KITTITAS COUNTY

TO: All Staff
FROM: Justin Turnbull, County Surveyor 
DATE: April 6, 2018
SUBJECT: County Survey Review of BLA BL-17-00021 Deneen

Note: CDS refers to this as BL-17-00021 Teaneway Ridge

**BOUNDARY LINE ADJUSTMENT**  
 PREPARED FOR  
 DAT DENEN

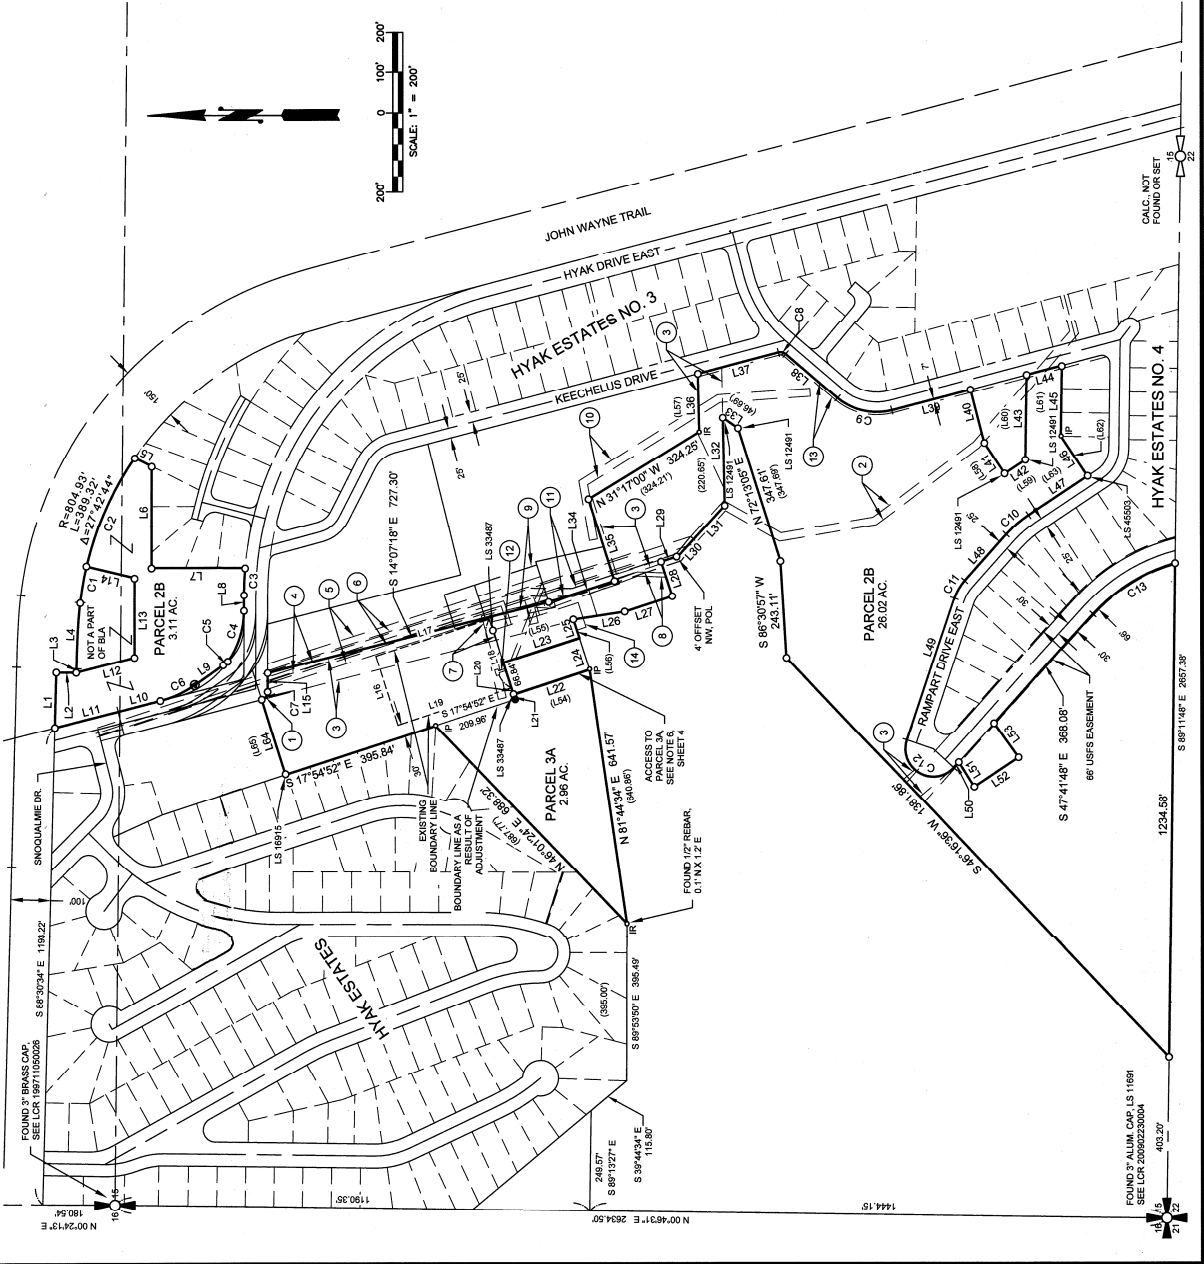
1. The document is missing line and curve tables, these should be added prior to final document preparation.
2. The document is missing a surveyors certification. This should be added prior to final document preparation.

3. The note "see note 6, page 2", located on Parcels 2 and 2B, refers to a non-existent note.
4. The page numbering should be corrected to reflect a 4 page document.

5. The R/W widths and easement width of Rampart drive is confusing. A detail window, or a note referring to the survey of record that clarifies the 60' R/W and 66' easement, would be helpful.

6. The existence of Parcels 2 and 2B is misleading, as it could be perceived that they are unique parcels, rather than portions of the same parcel. If the intent is to create 3 unique parcels, then a third parcel should be included in the BLA, or alternatively a short plat should be prepared, rather than a BLA.
Changing Parcel 2B to "Pt of Parcel 2" would resolve this.

7. The parcel located North of Parcel 2B is misleading with the heavy boundary line and could be corrected with a note or by labelling it as "Not a part". I have no issue with showing or delineating adjacent parcels as part of a BLA process, but it should be made clear that they are not included with the BLA process.

8. Minor typo in Line 1, of survey notes: Change Parcel to Parcels.
9. To clarify references within the existing legal descriptions, Snoqualmie Drive could be labeled, as the East extent is the point of beginning for multiple parcels.
